Application number: 2020/94203.

The application is for demolition of dwelling and associated outbuildings etc.

The address of the site or building is: Clough House, 236 Leeds Road, Birstall,
Batley, WF17 0HW.

Proposed Layout

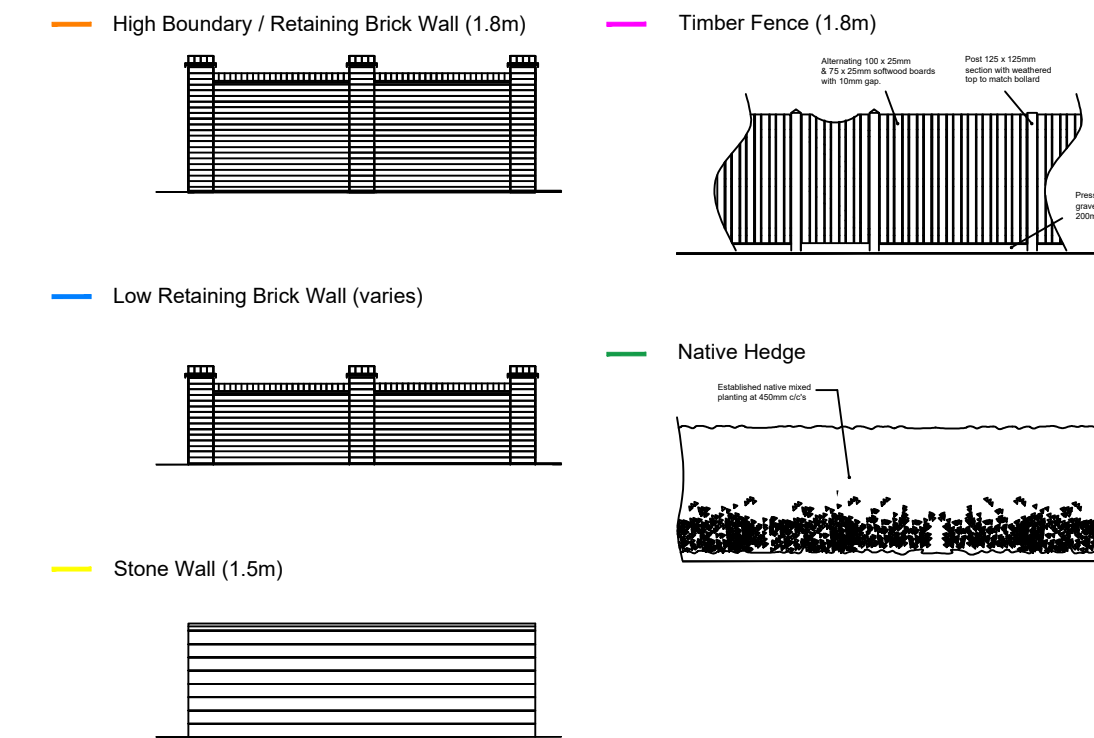
Having perused the plans and associated documents, I was surprised to see that the development would be split into two cul-de-sacs, with 23 dwellings in the 'northern' cul-de-sac, utilising the proposed access from Moat Hill Farm Drive, and the other 7 dwellings in the 'southern' cul-de-sac (which seems to be somewhat insular) with their own access via the A643, Leeds Road, but no vehicular access to either the 'northern' cul-de-sac, or elsewhere.

Within para. 3.10 (page 26) of Kirklees SPD, Highway Design Guide – November 2019, it states: 'Cul-de-sac layouts will normally be discouraged, unless absolutely necessary due to exceptional circumstances.' I do realise that this refers to developments of over 300 dwellings. However, in all cases, a stipulated priority requirement is to provide easy access to dwellings for emergency vehicles and refuse collection for all developments. This does not appear to be the case in this proposed development.
